Date: April 29 2025

File: 073124 - 45 Oak Street

URBAN DESIGN REVIEW PANEL REPORT - 45 OAK STREET

ÉÉP LOUISE-ARBOUR 45 OAK STREET, OTTAWA, ON

GROUND FLOOR PLAN
1:175

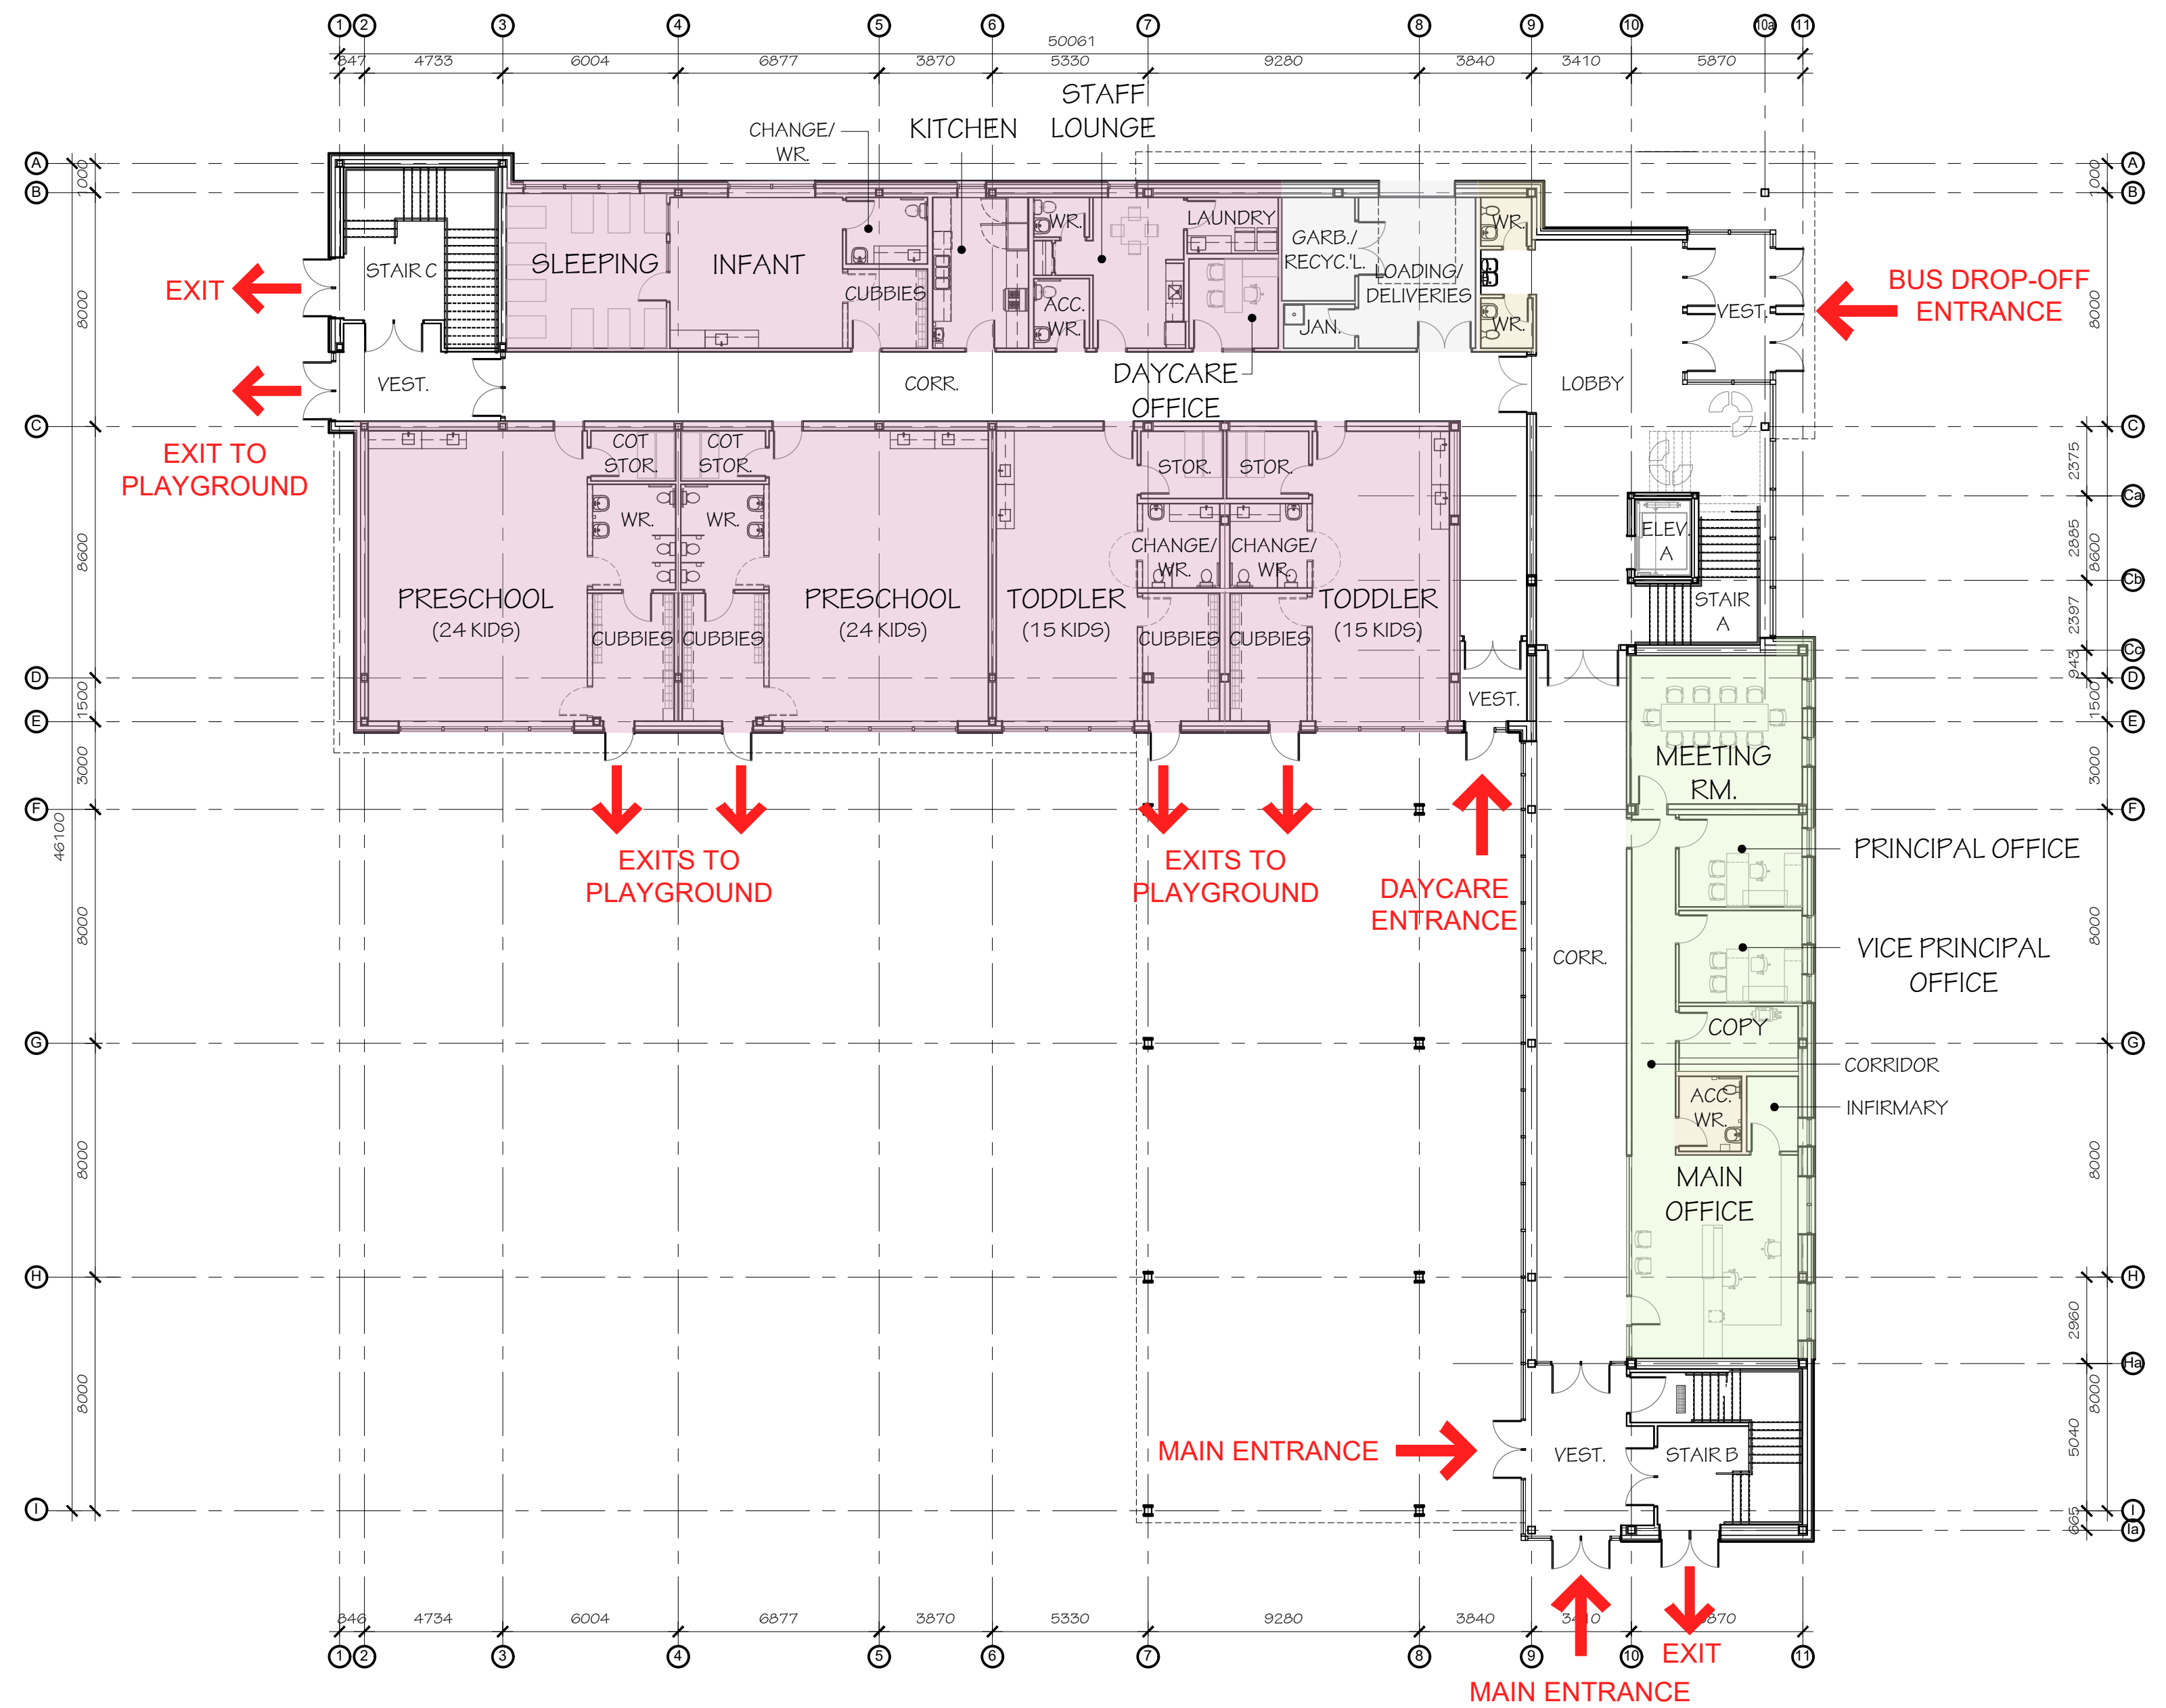
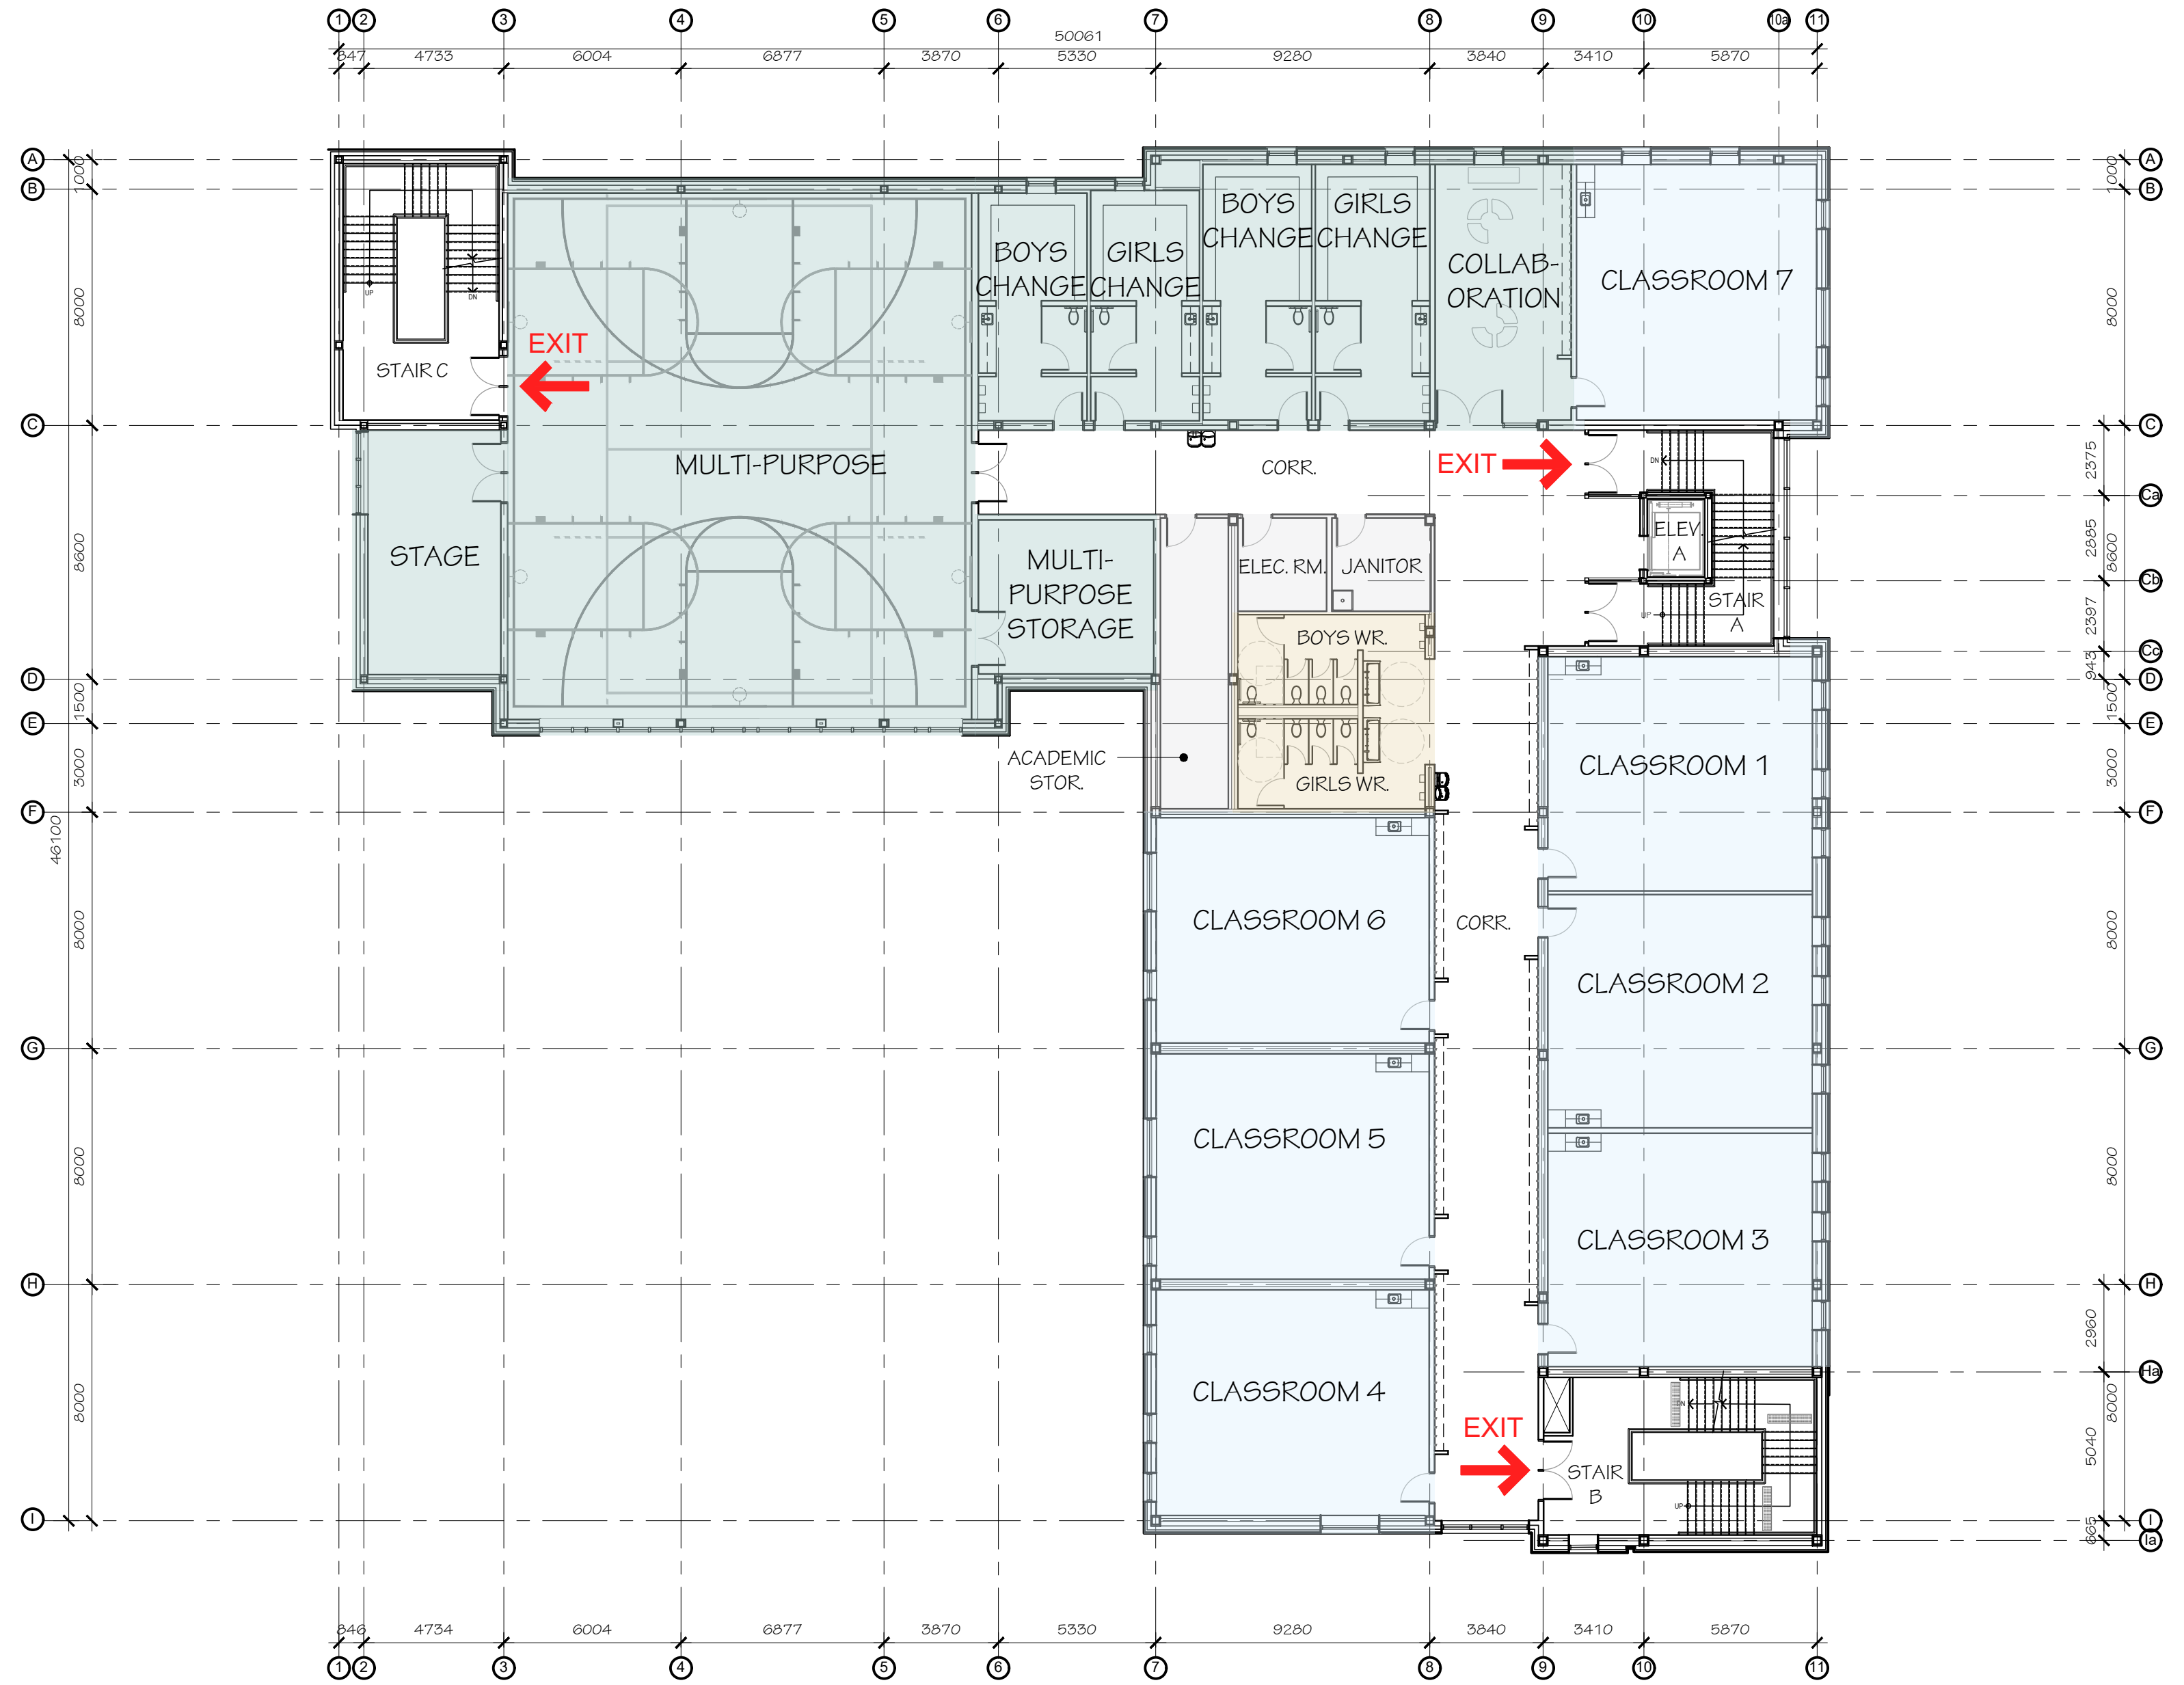
(20 of 25) The Panel appreciates the urban school typology and its potential to deliver a compact, multi-level education facility, but recommends refining the schools architectural expression to reflect its identify more clearly.

(21 of 25) The Panel suggests reconsidering the neutral architectural language of the school, proposing a more playful and colourful palette that distinguish it from adjacent residential towers.

The recommendation is appreciated and the team will review the architectural expression as the details of the design evolve through the Site Plan Control process.

The recommendation is appreciated and the team will review the architectural expression as the details of the design evolve through the Site Plan Control process.
